Email Advice from Bega Valley Shire Council

From: Newton, Peter
Sent: Friday, 16 April 2010 12:48 PM
To: 'jarmstrong@secc.com.au'
Cc: 'mark.schofield@planning.nsw.gov.au'
Subject: MP 06-0147 Ivor Jones Drive Wonboyn

DRAWING TITLE		
PLAN & LONGITUDINAL SECTION OF ACCESS ROAD CH 00 - CH 360		
Project No. 07000168	Drawing No. 02	REV A

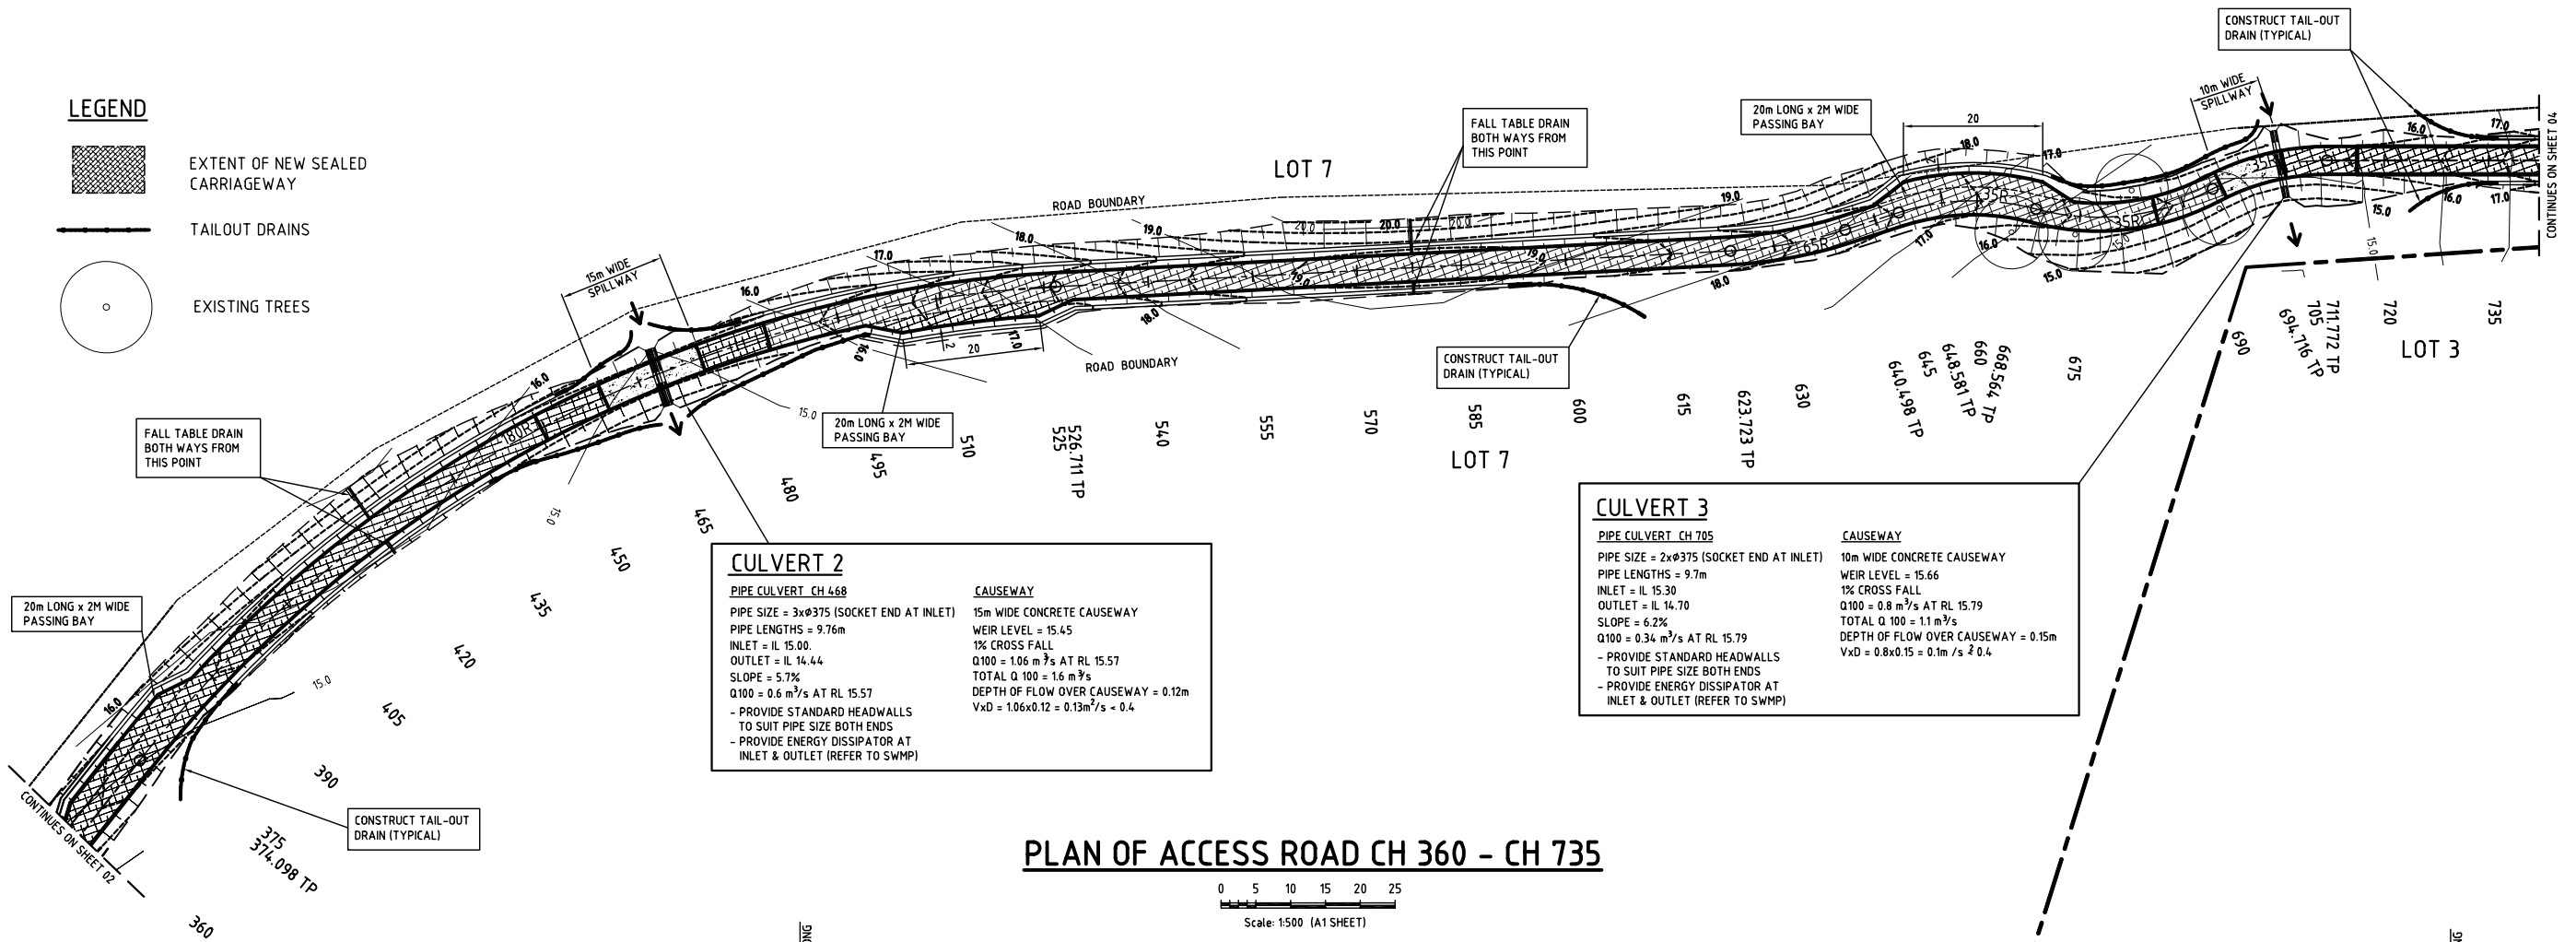
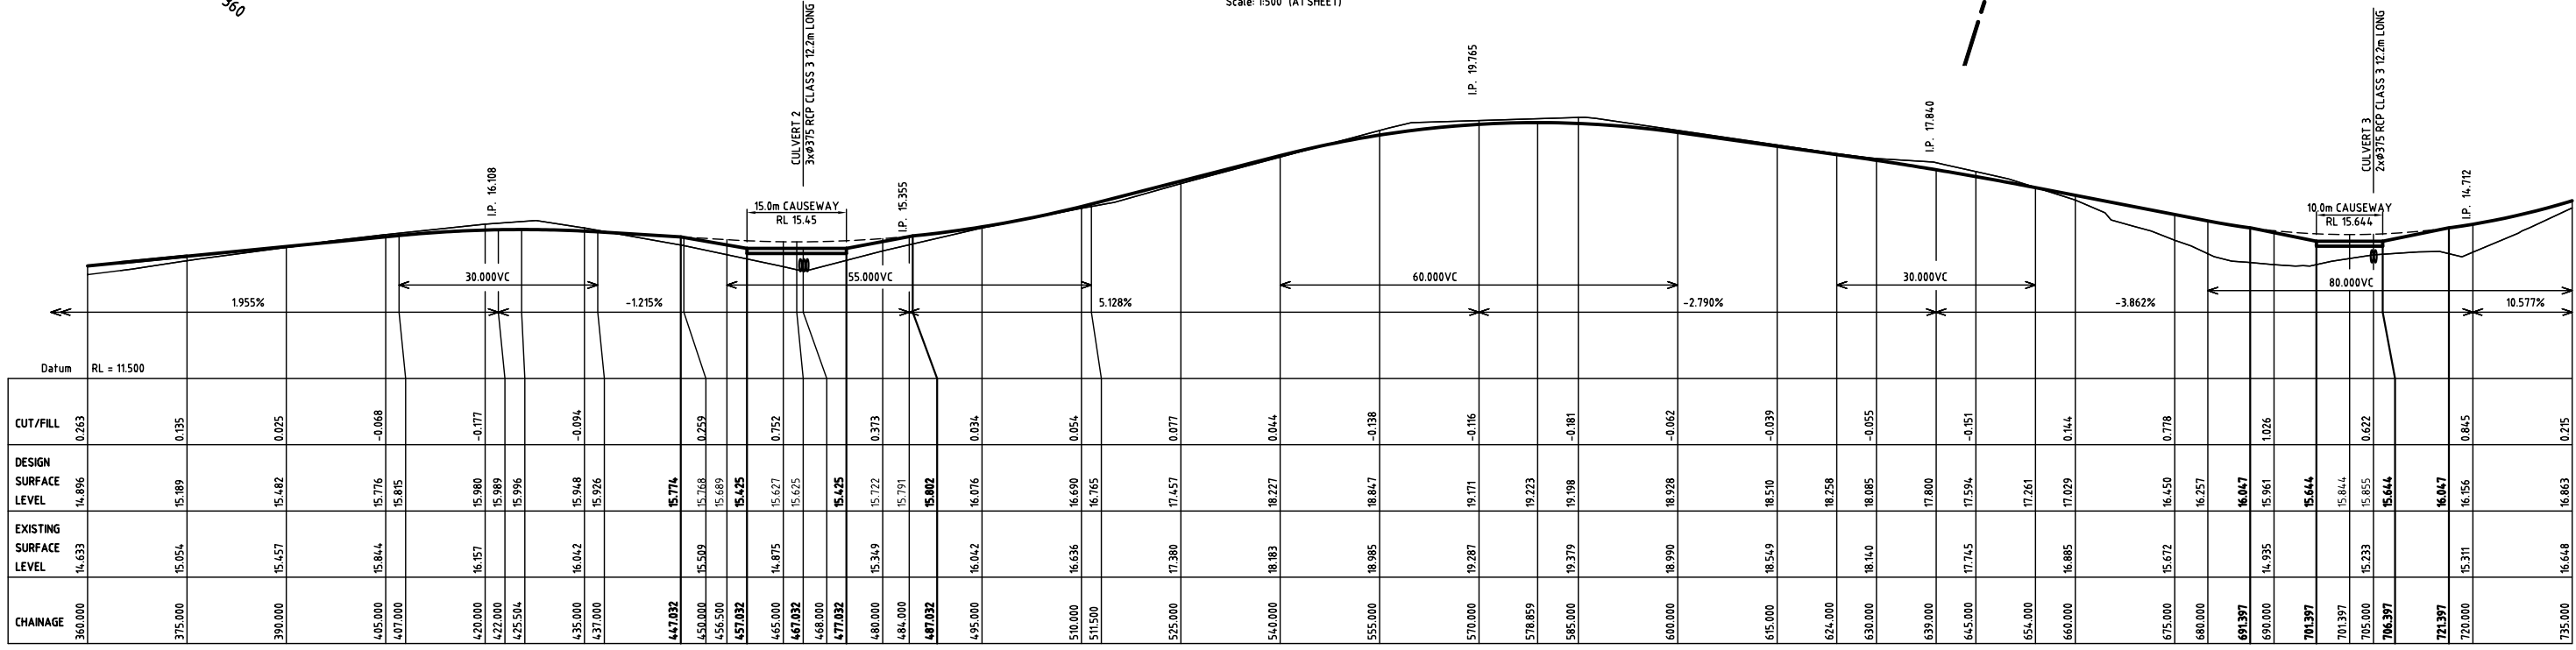
Further to our discussions regarding the above matter, the design as proposed (and attached) would be acceptable to Council with the provision of the 4.0 metre wide bitumen sealing to be extended to 20 metres past the access to the last proposed lot. This of course includes the proposed passing bays as nominated.
